**Sent:** 07 October 2011 12:00  
**To:** Planning  
**Subject:** Planning application S6/2011/1709/FP - Carbone House, Carbone Hill,

**Response to Planning application from Hertfordshire County Council (T and CP GDP Order 1995)**

**District ref:** S6/2011/1709/FP  
**HCC ref:** WH/245/2011 (Amended)  
**HCC received:** 06/10/2011  
**Area manager:** James Dale  
**Case officer:** Lindsey Lucas

Formation of new vehicular access following removal of existing vehicular access

Drq.No: AT355-20

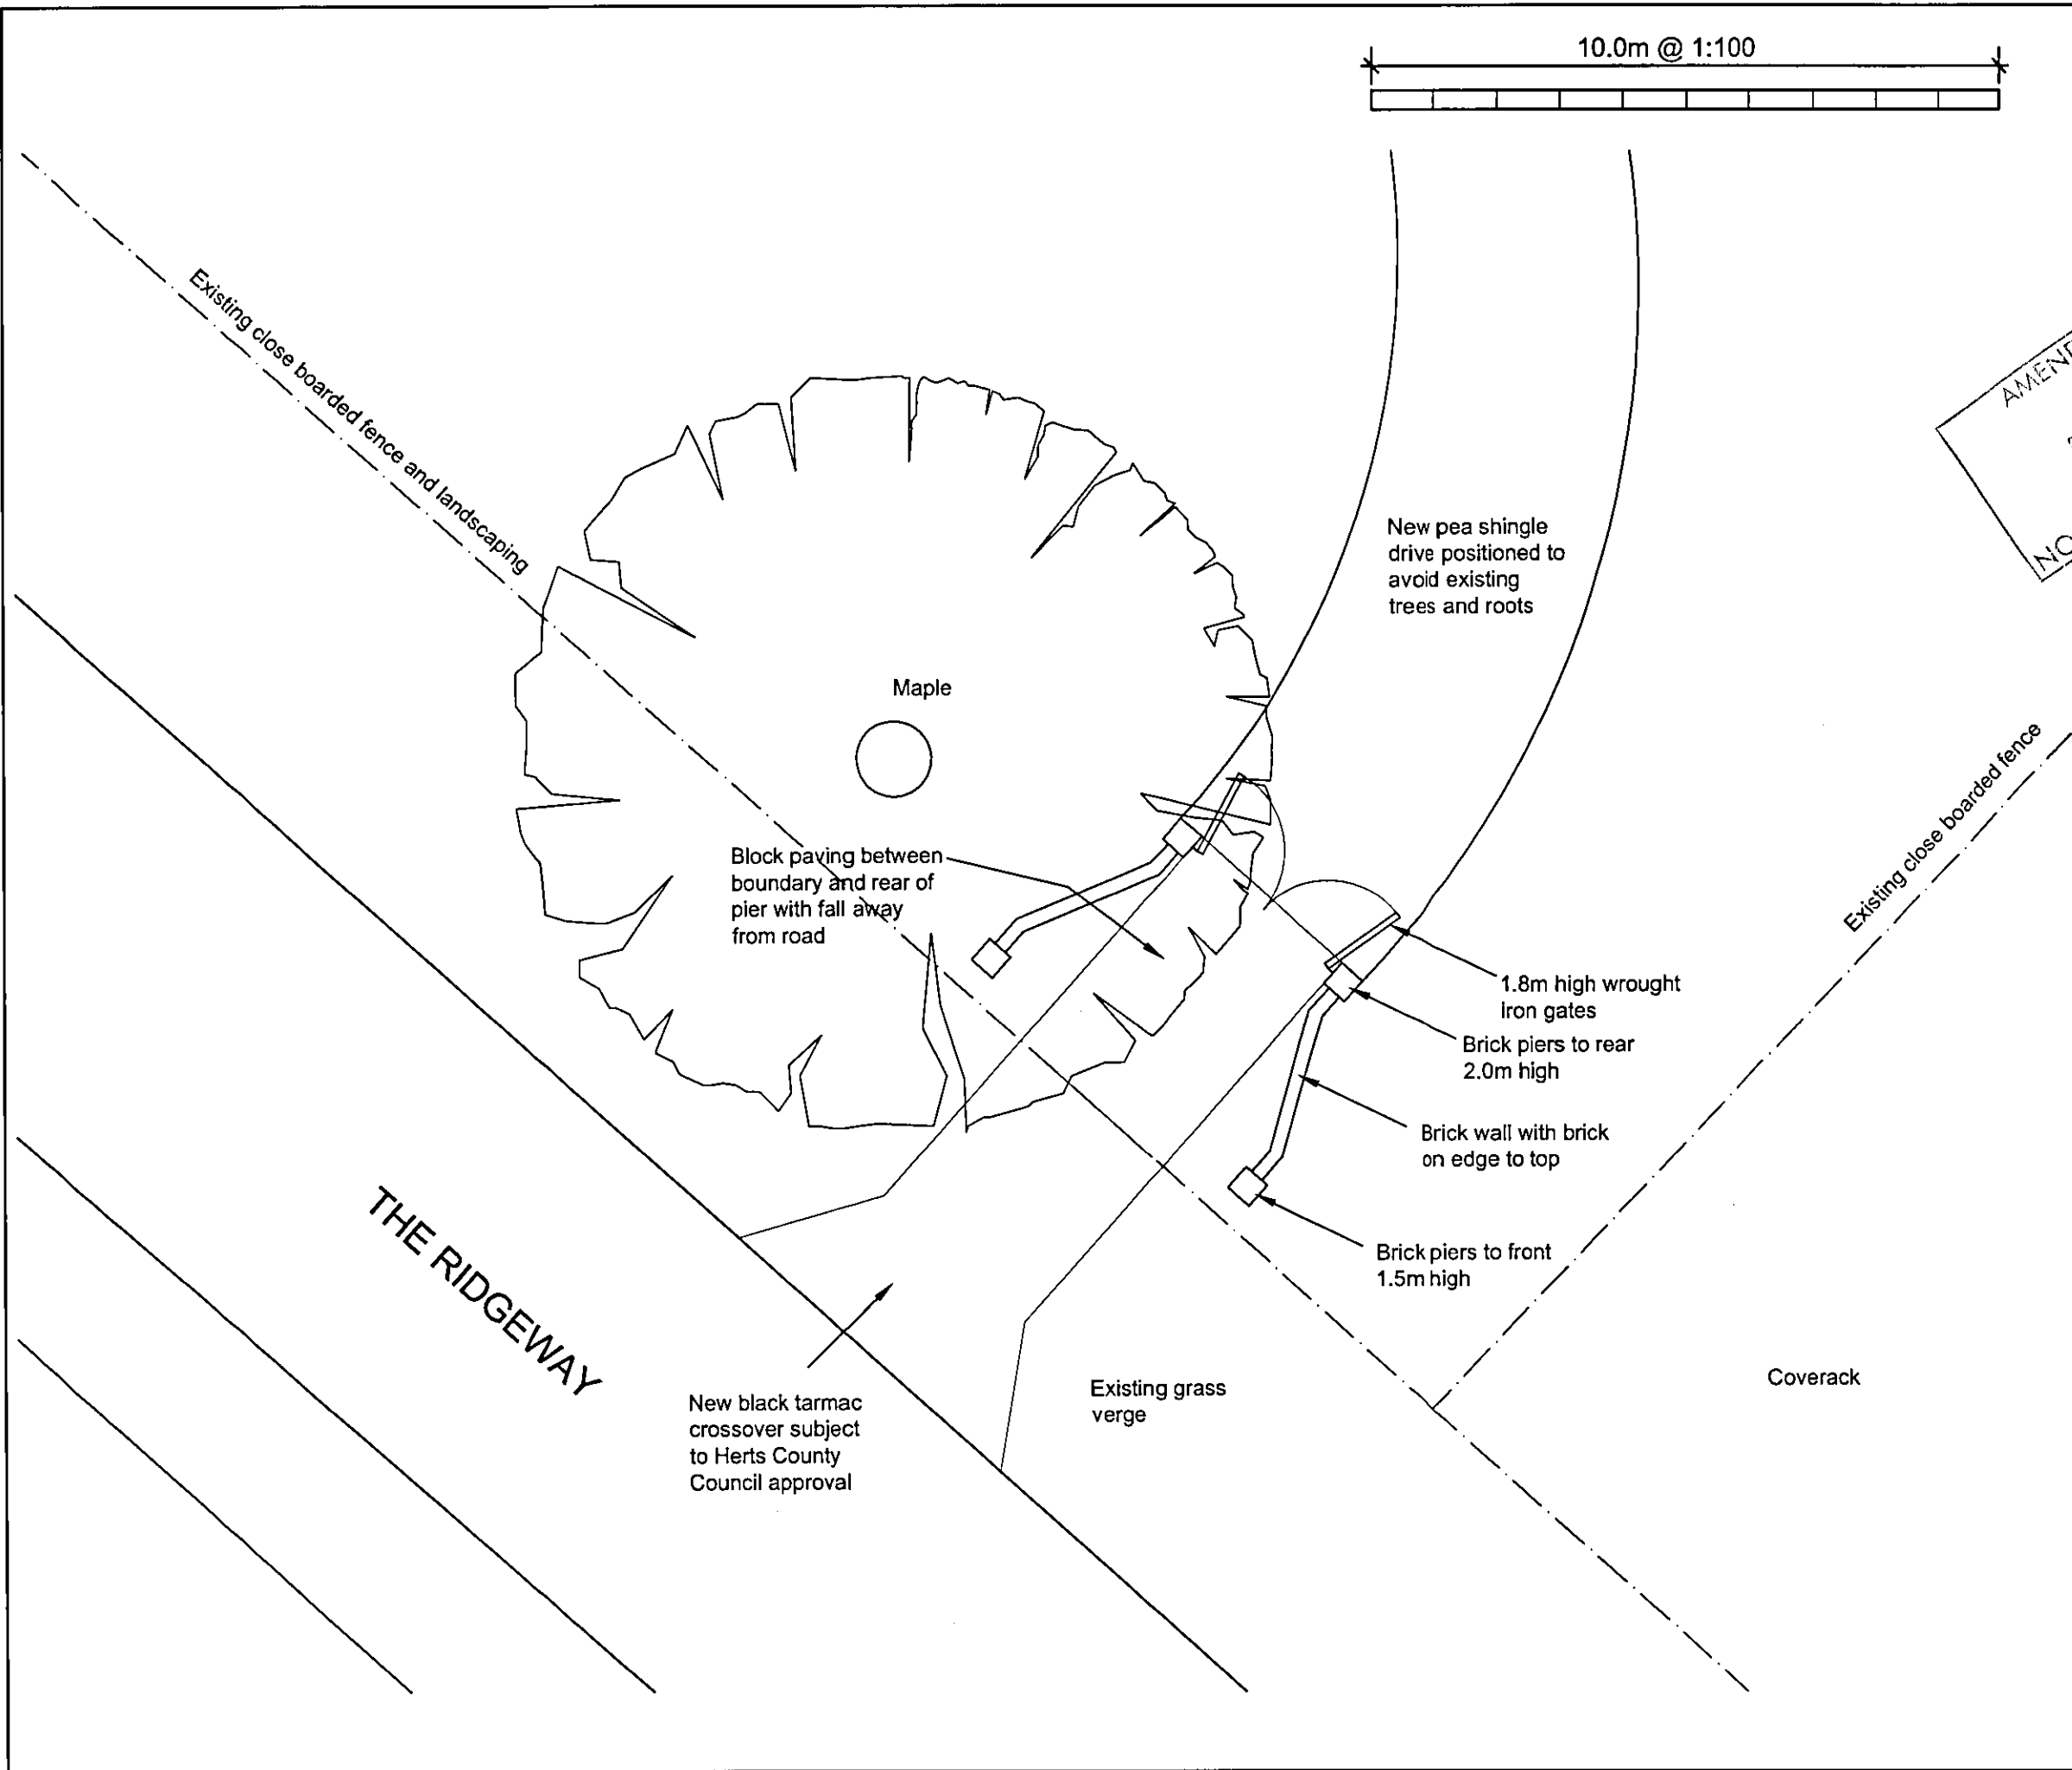
4. The gates should be located as shown on drawing number AT355-20 and shall open inwards into the site.

The highway authority would have no reason to object to the relocation of this access. The proposed access is better sited than the existing and visibility splays of 2.4m x 90m can be provided within the existing highway verge. The gates are set 6m back from the edge of the carriageway.

Reason: In order that a vehicle may wait clear of the highway while the gates are operated.
